**Sent:** 12 January 2012 11:22  
**To:** Planning  
**Subject:** Planning application S6/2011/2685/FP - Land adjoining 29 & 30 Greenfields

**Response to Planning application from Hertfordshire County Council (T and CP GDP Order 1995)**

**Location**  
 Land adjoining 29 & 30 Greenfields  
 South Drive,  
 Cuffley

**Proposal**  
 Erection of two bungalows

SITE PLAN - scale 1:200

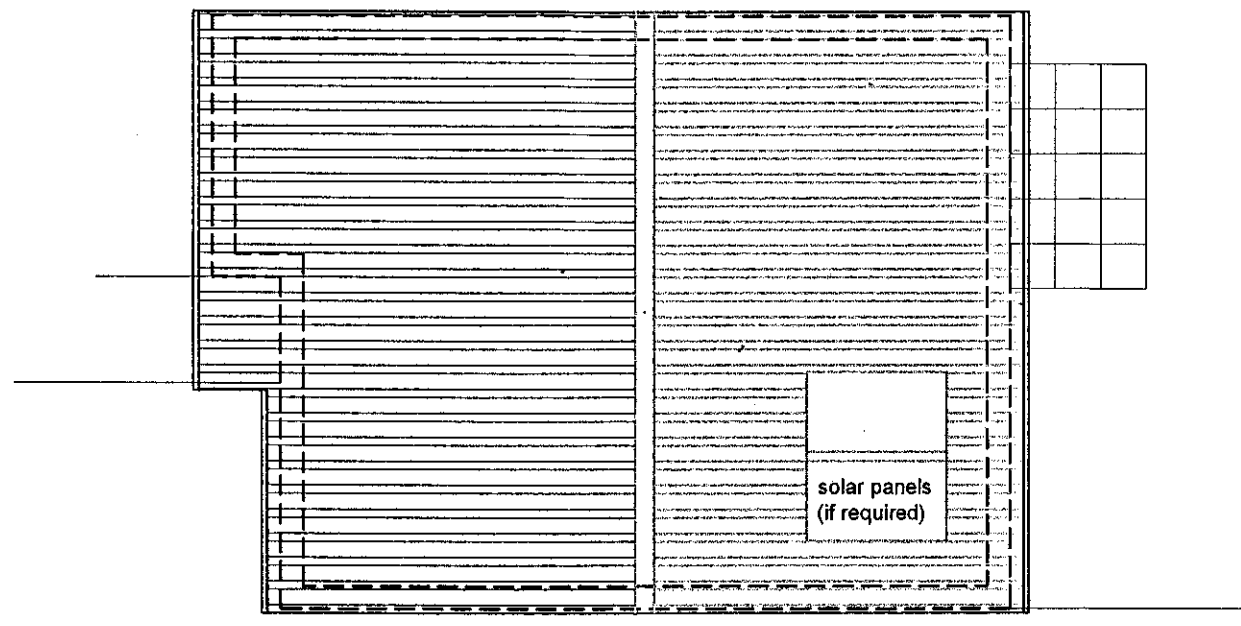
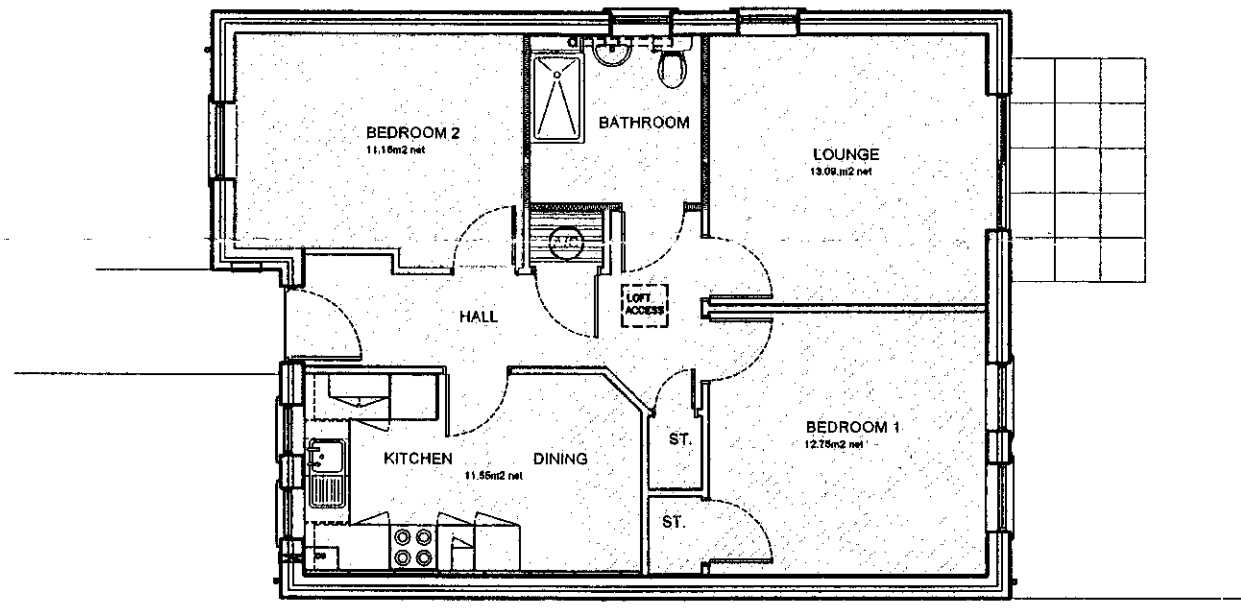
1. Prior to first occupation of the development the associated car parking shown on approved plan 12021/001 shall be laid out and used for no other purposes. Reason: To ensure the development makes adequate provision for the off-street parking and manoeuvring of vehicles likely to be associated with its use.
2. C8.13 - No unbound material shall be used on the proposed access within 20 metres of the highway boundary. Details of the proposed surface dressing shall be submitted to and agreed in writing by the local planning authority, prior to the commencement of the development and implemented in accordance with those details

COMMENTS: This application is for two dwellings and three new parking spaces which would be accessed from the southern end of South Drive. South Drive is a local access road and it is proposed that the existing kerb would be removed to provide access to the three parking spaces.

It should be noted that the footway at the southern end of the road is not part of the public highway, whereas the carriageway is. To provide the access to the proposed parking spaces a new crossover will be required from the carriageway and the applicant will need to discuss the procedure for carrying out this work with Mid West Hertfordshire Highways Area Office (Telephone 01727 816000).
